File: SF18/66698
Job ID No: DOC18/620558
Your Ref: SSD7665

RE: Response to Modification request for Sydney Opera House (SOH), Joan Sutherland Theatre (SSD 7665 MOD 1)

Tim Smith OAM
Director Heritage Operations
Heritage Division
Office of Environment & Heritage
13 September 2018

4 N-S SECTION THRUST BLOCK 1:50

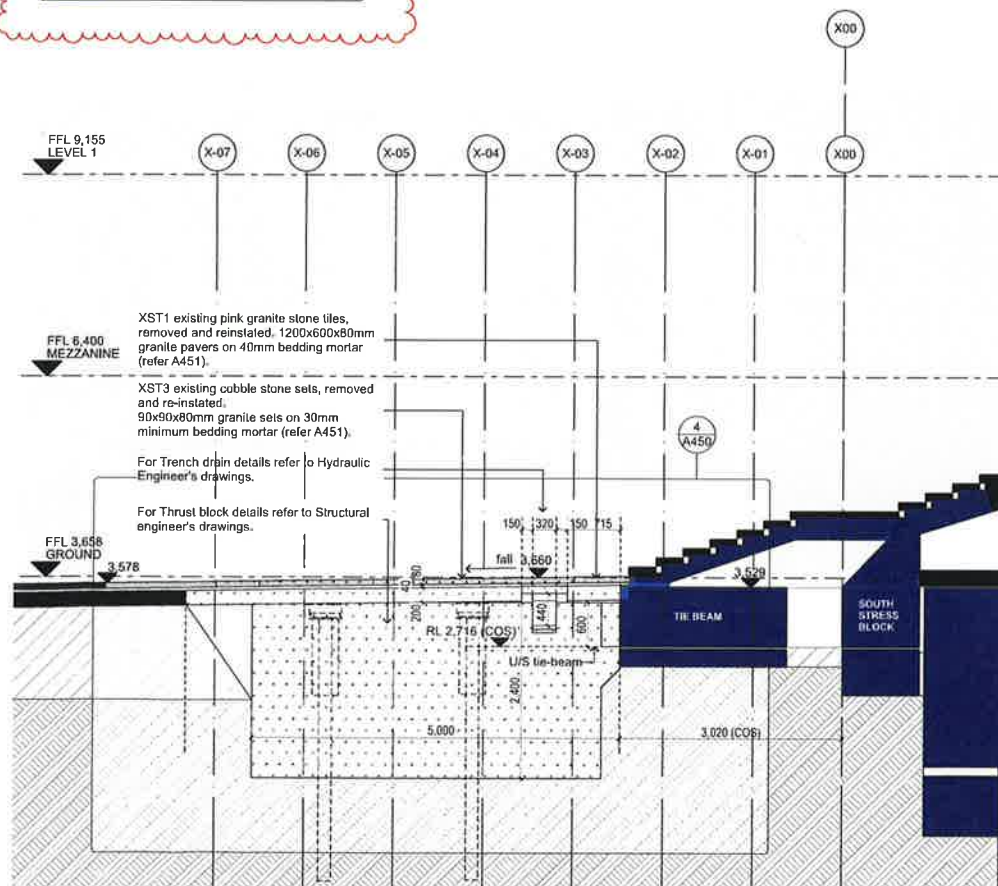
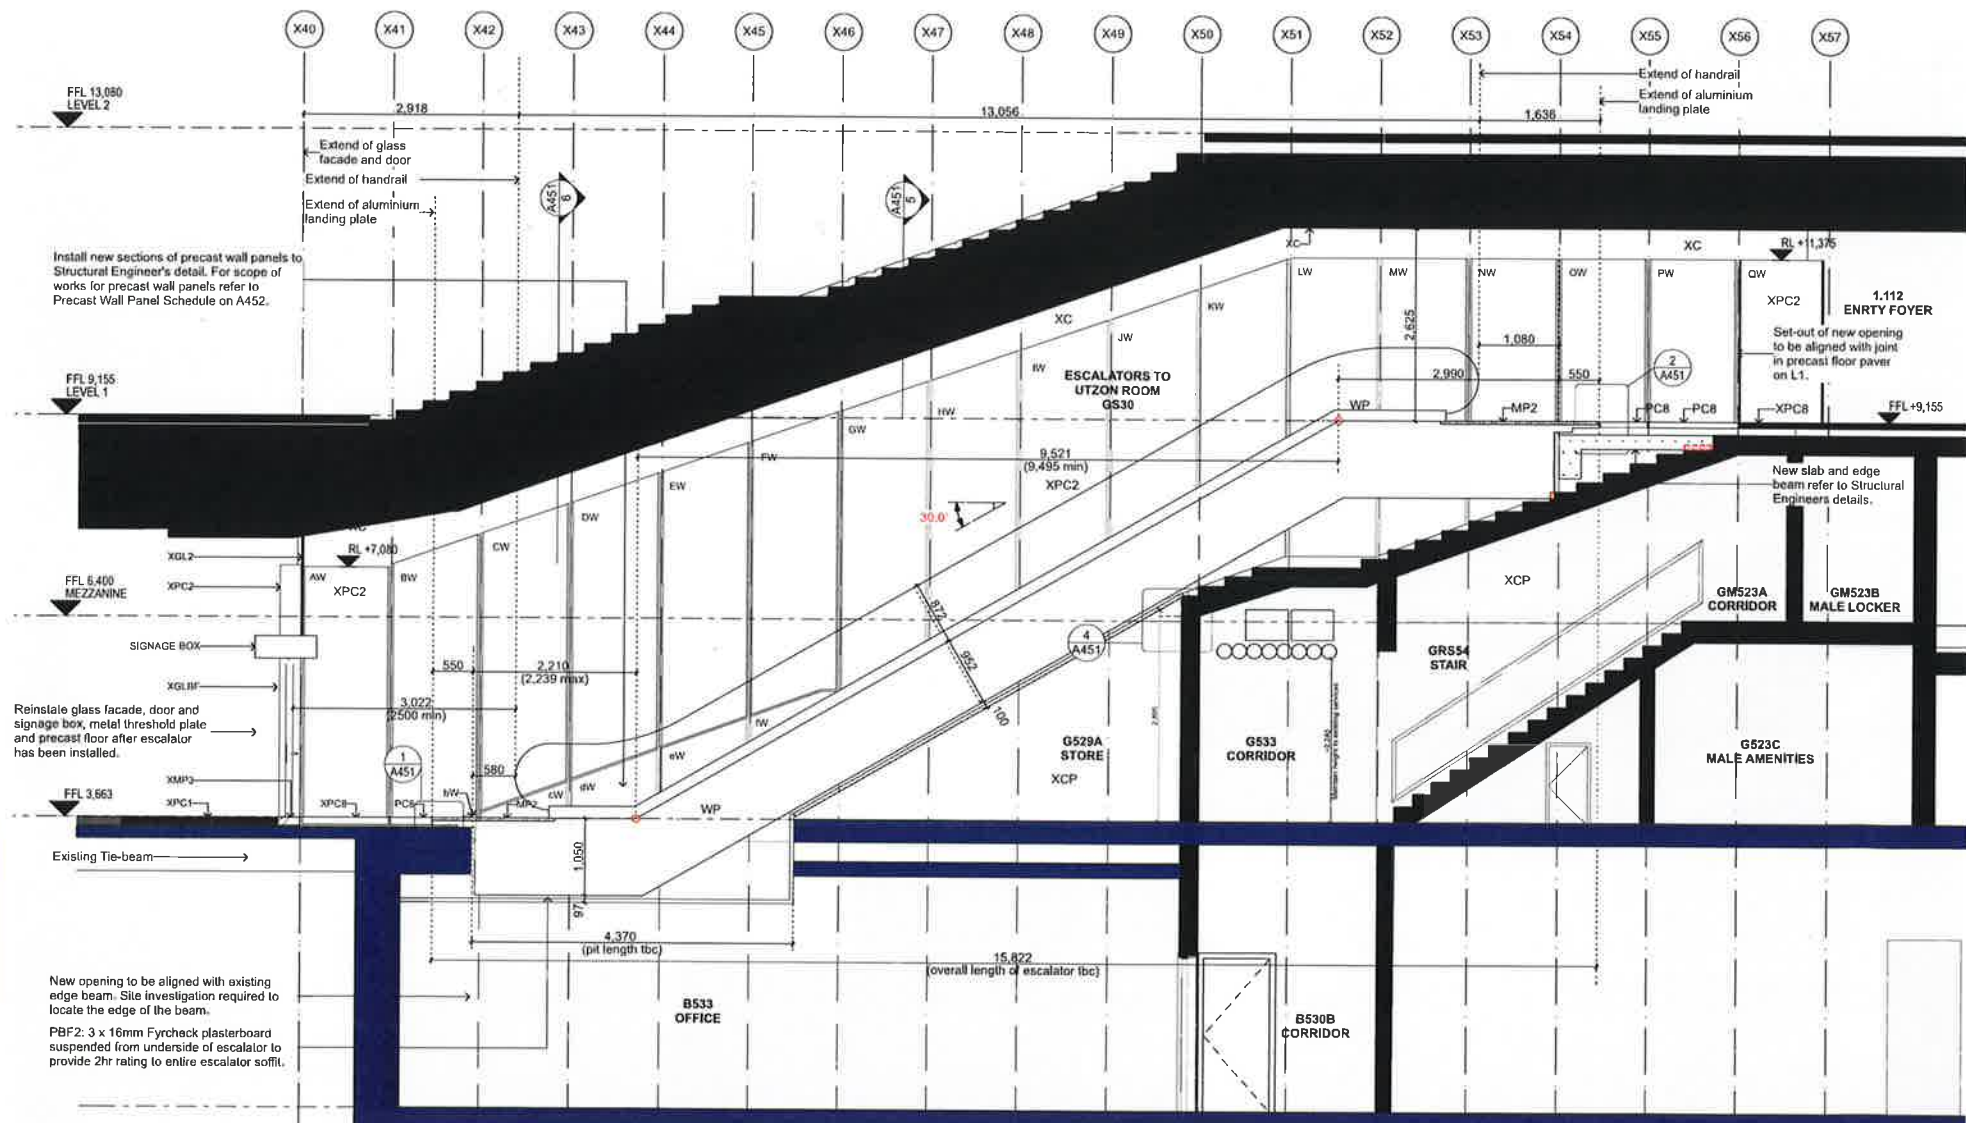
We understand that these works are required to facilitate the installation of the approved escalator as part of SSD 7665. The works include the cutting of two original tie beams and construction of a new concrete thrust block.

- The interdependence of the tie beams, folded concrete beams and steps is well understood and documented, with intervention to a number of tie beams undertaken when the lower concourse escalators were installed previously. It is therefore unclear why the conflict between the tie beams and escalator pit was only recently identified and a thrust block required.

- The proposed works will have a physical impact to the SOH's original structure and fabric.
- The proposed works provide an opportunity to understand this component of the existing structure of the SOH. Should the modification be approved, it is recommended that archival recording is

undertaken once the tie beams are uncovered to document the existing conditions prior to cutting works being undertaken.

- A structural assessment must be undertaken within 12 months following completion of the works to ensure any impacts to the structural integrity of the significant folded concrete beams are identified and appropriately addressed.

- An archival photographic recording of all the affected areas is to be undertaken prior to, during and after the cutting of the tie beams to document the changes occurring to the structure, in accordance with the Heritage Division document entitled, *Photographic Recording of Heritage Items using Film or Digital Capture*. The original copy of the archival record shall be submitted to the Heritage Division within one month of the works completion.
